### **Santa Short Plat File Number SP-19-00003 FINDINGS OF FACT, DECISION AND CONDITIONS OF APPROVAL**

**Requested Action:** Mick C. Santa, landowner, has submitted a preliminary short plat application to subdivide approximately 10.128 acres into two (2) parcels, one (1) 5.0 acres parcel and one (1) 5.128 acres parcel. The subject property is zoned Agriculture 5.

BIG CREEK II SHORT PLAT

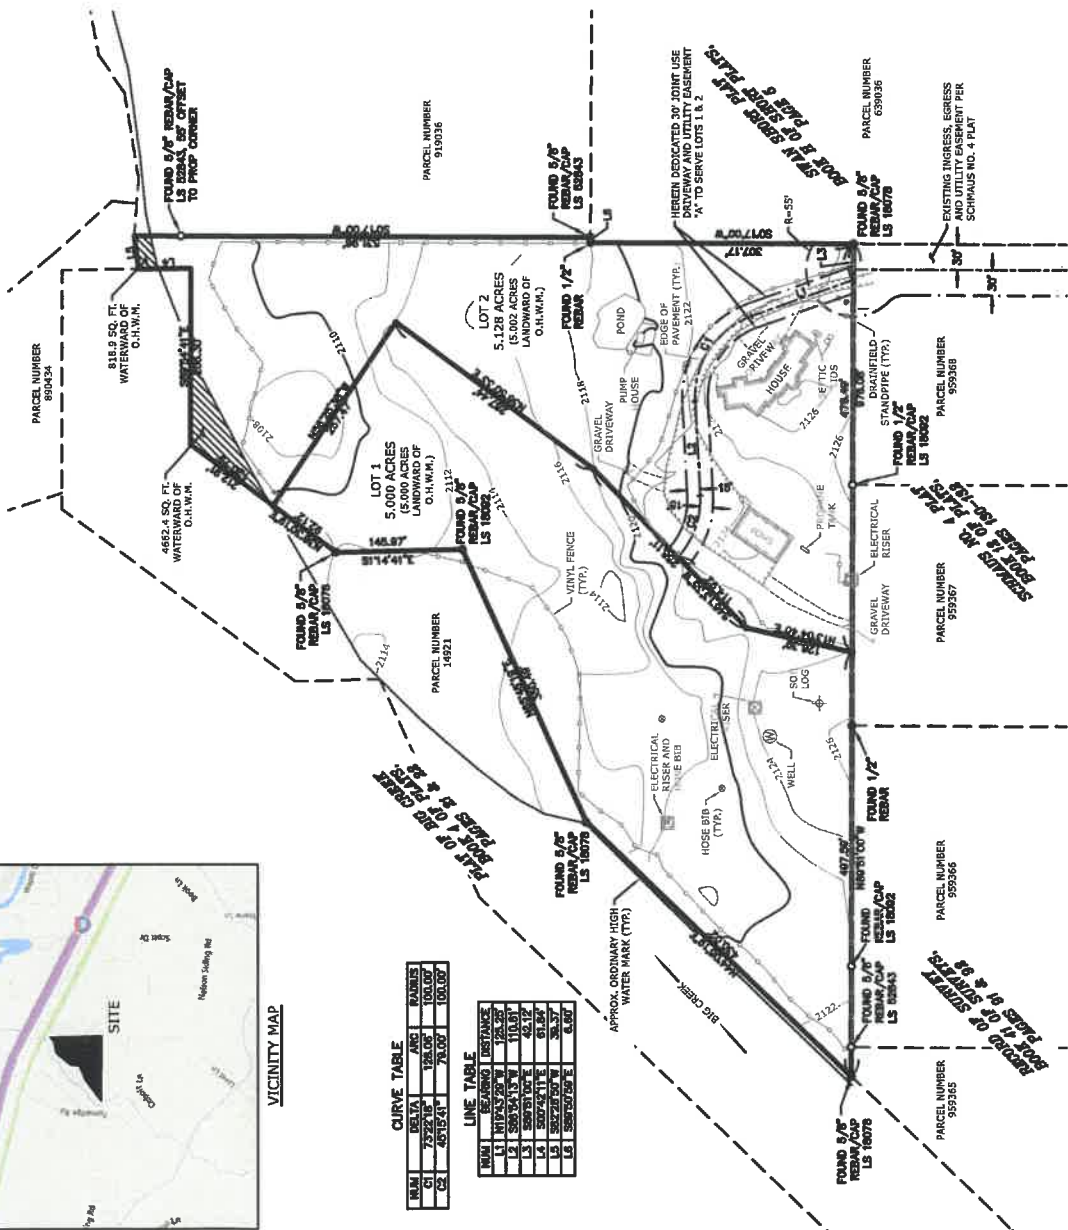
- 8. Survey**
- A. The vicinity map cannot be color or grayscale at final recording.
  - B. Dimensions located at the North portion of Lot 2 are obscured by hatching.

- C. There will need to be an easement created for Lot 2 to access the shared Well location.
  - D. Per KCC: 16.12.110, Utility easements will need to be shown for the lines serving the shown electrical risers.
